2021/0981

The Willow, Lane Head Road, Cawthorne, Barnsley, S75 4DP

Rear Elevation as Proposed
(scale 1:100)

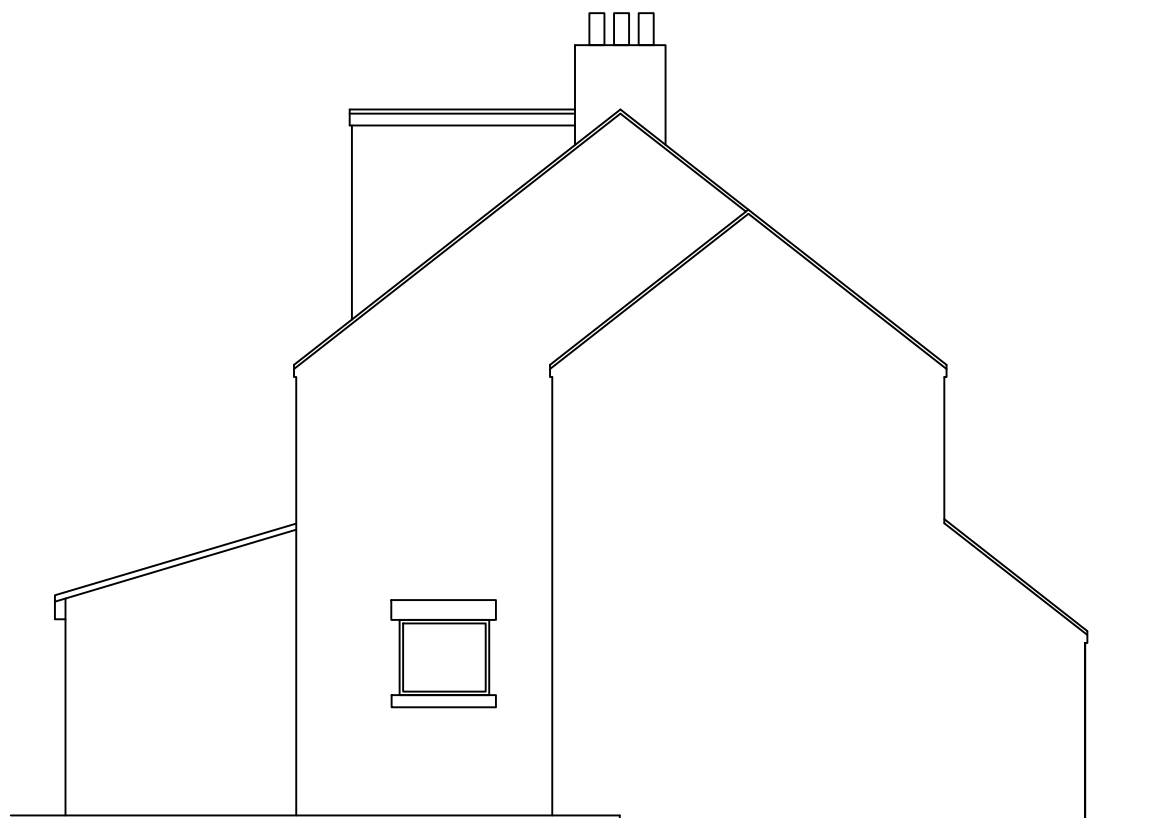
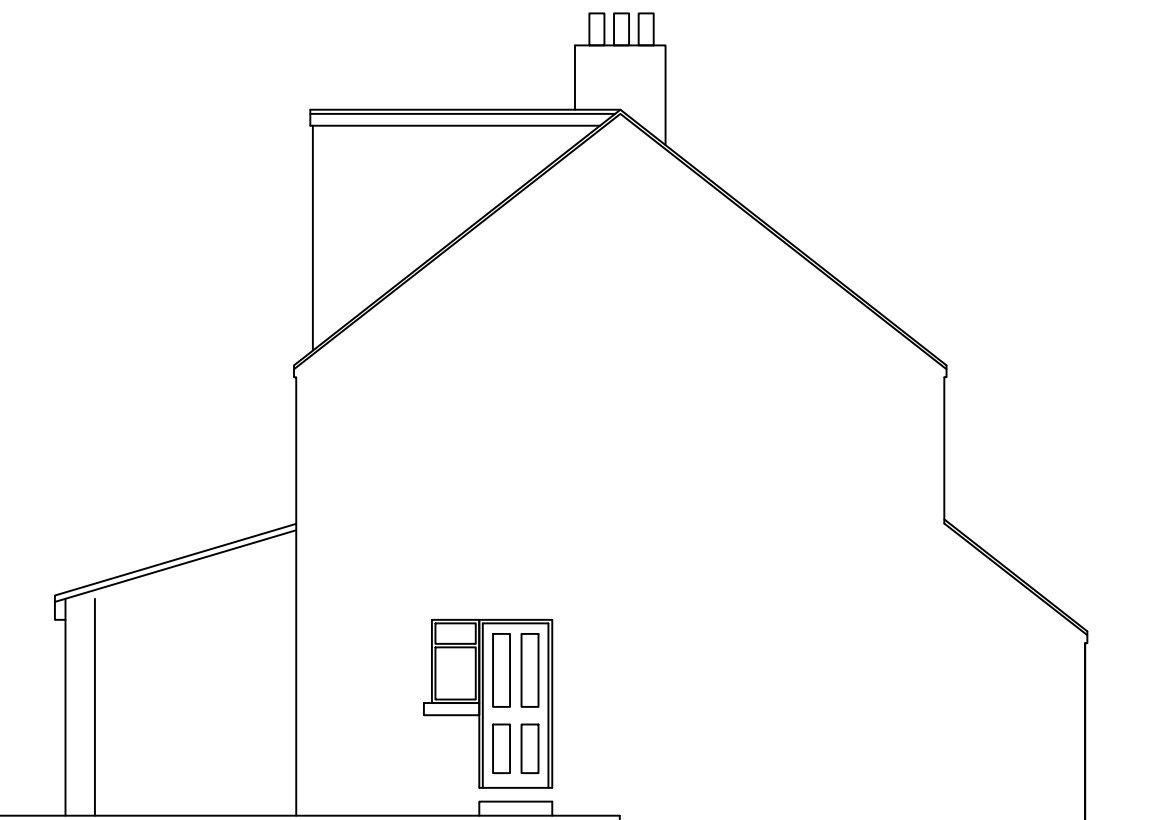
The proposed extension to the rear of the existing two storey side extension would bring the roof up to the height of the existing dwelling, normally with any two storey side extension we would expect a set back from the front elevation, however in this instance there is no set back as existing. Whilst raising the roof would result in the extension having a less 'subservient' appearance, as the extension is historic it is felt that it would be unreasonable to refuse permission for this small extension to the roof on this basis alone. In addition, there is a front projecting garage element which helps to break up the extension with the existing dwelling. In this instance and on balance, the proposal is considered to be acceptable.
